Your Ref:
Our Ref: EP/9/20/DOC

Town & Country Planning Act 1990 (as amended)
Town and Country Planning (Development Management Procedure) (England) Order 2015
Approval of details reserved by condition imposed under ref EP/160/16/PL relating to Condition Nos 6 -
existing trees/hedges/bushes retained and protected and 7 - landscaping scheme
Green Willow Care Home Vicarage Lane BN16 2SP

Arun District Council have decided to **APPROVE details reserved by this condition**

Scale 1:200 @ A1, 1:400 @ A3
Date October 2019
Dwg. No. 21628 / 27 / A

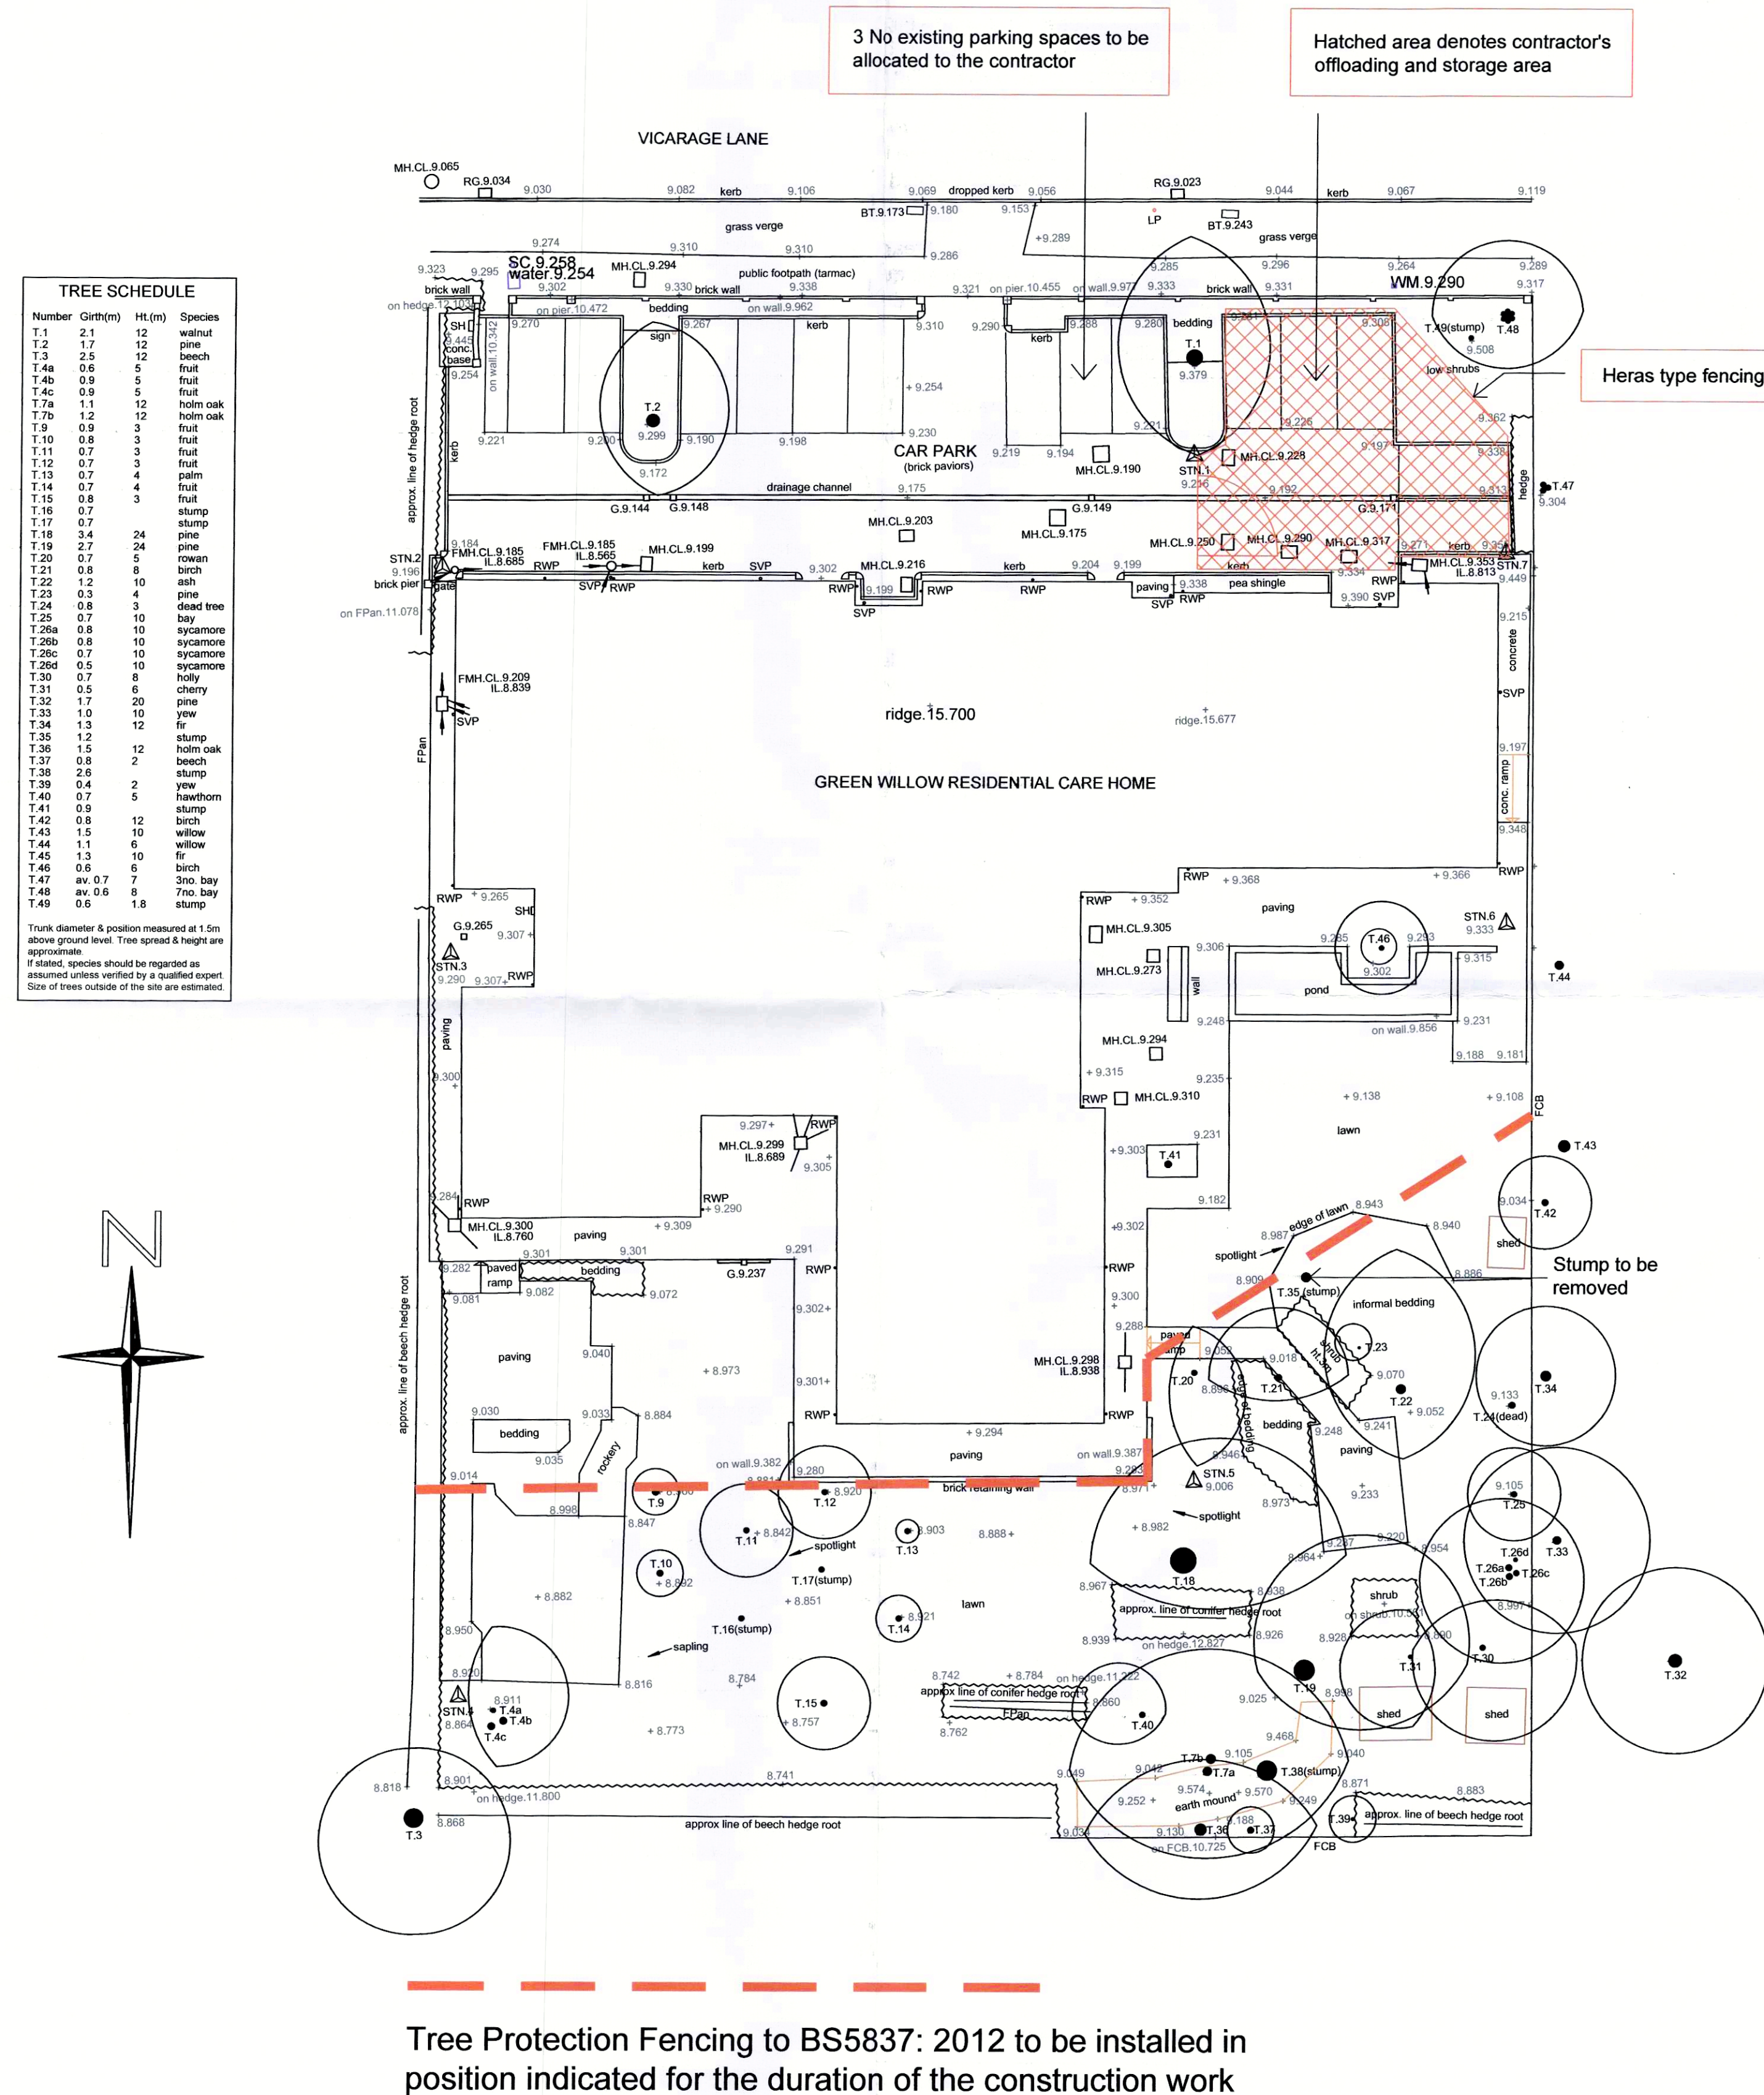
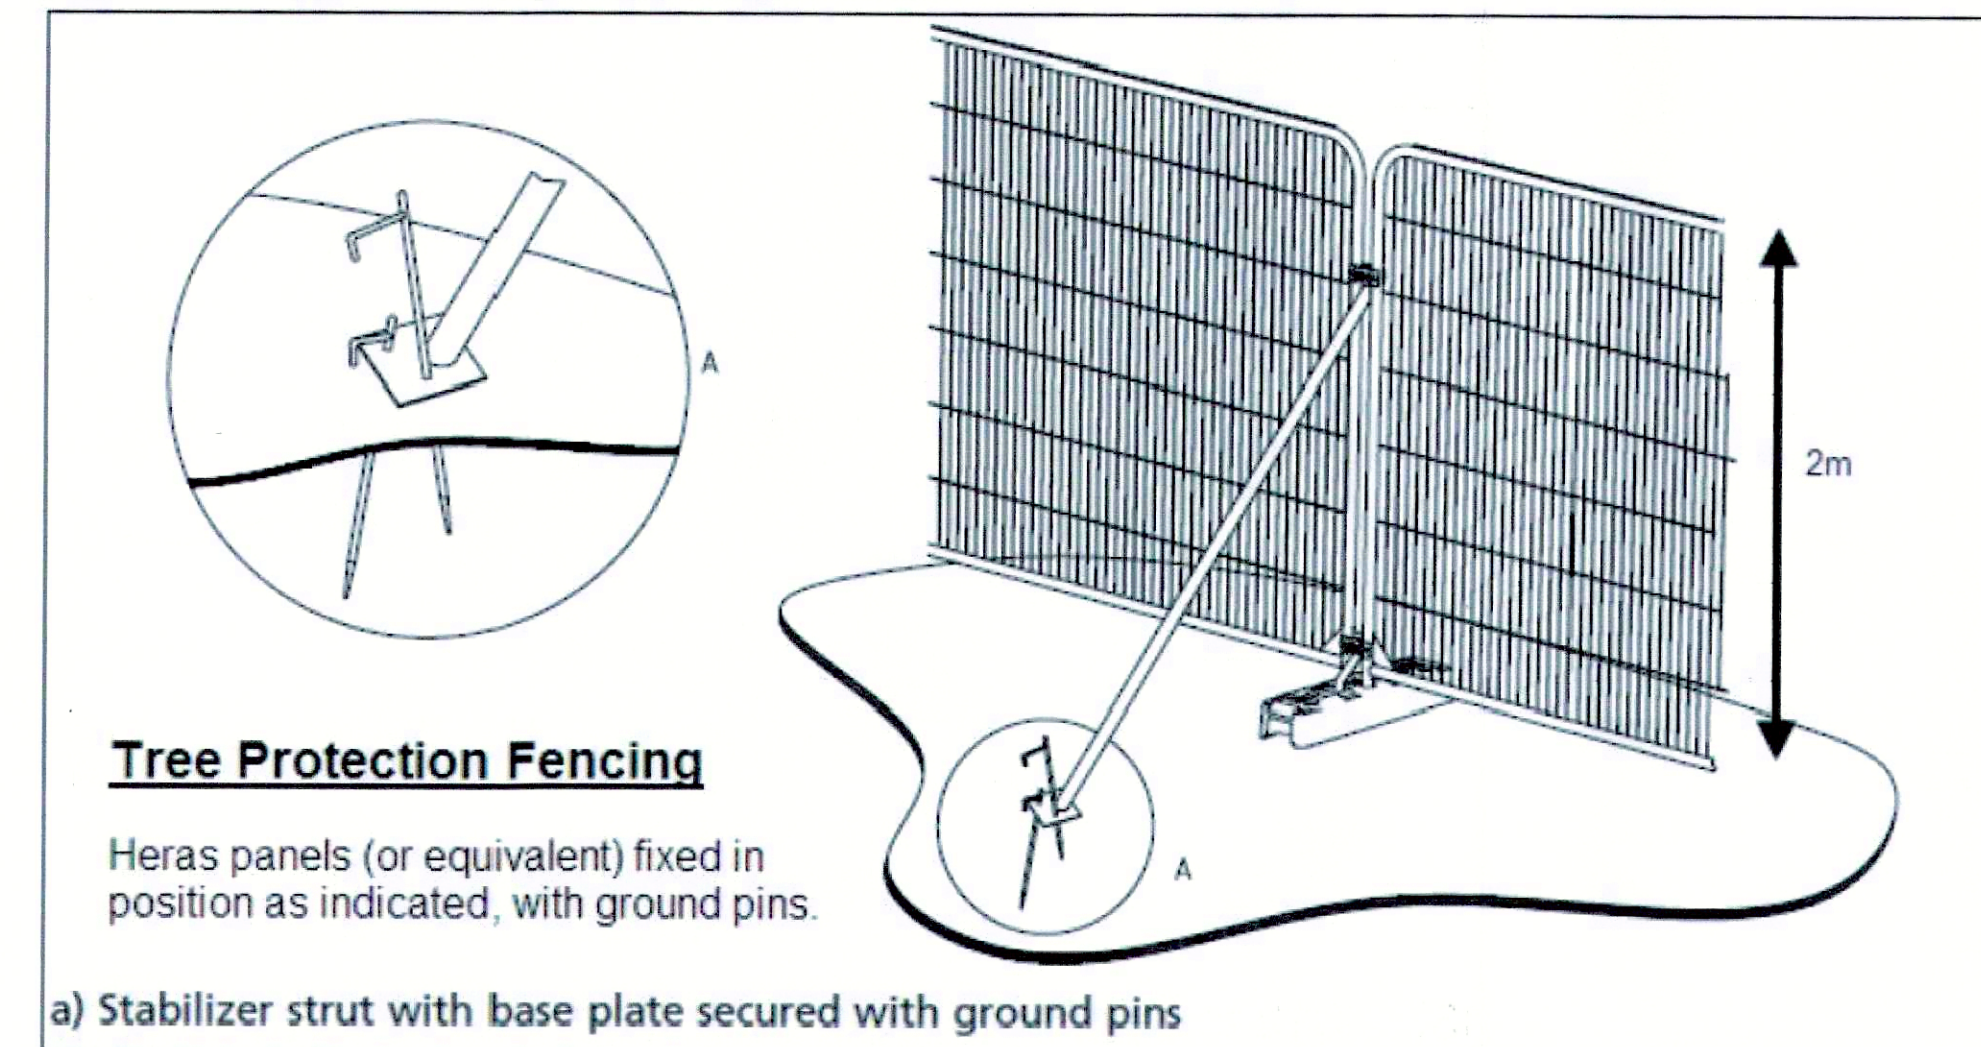
It is noted by the Trees Officer that although the submitted plan does not meet the requirements of BS5837:2012 (has not been prepared by a suitably qualified and experienced arboriculturist, nor illustrate trees and their root protection areas with tree protection measures overlaid), the tree protection measures described and illustrated on the aforementioned plan are logical and adequate for such a straightforward project and therefore these measures can be recommended for approval.

- Existing Landscaping Plan & Site Management & Construction Phase Plan (Drawing Number: 21628/ 27 / A)
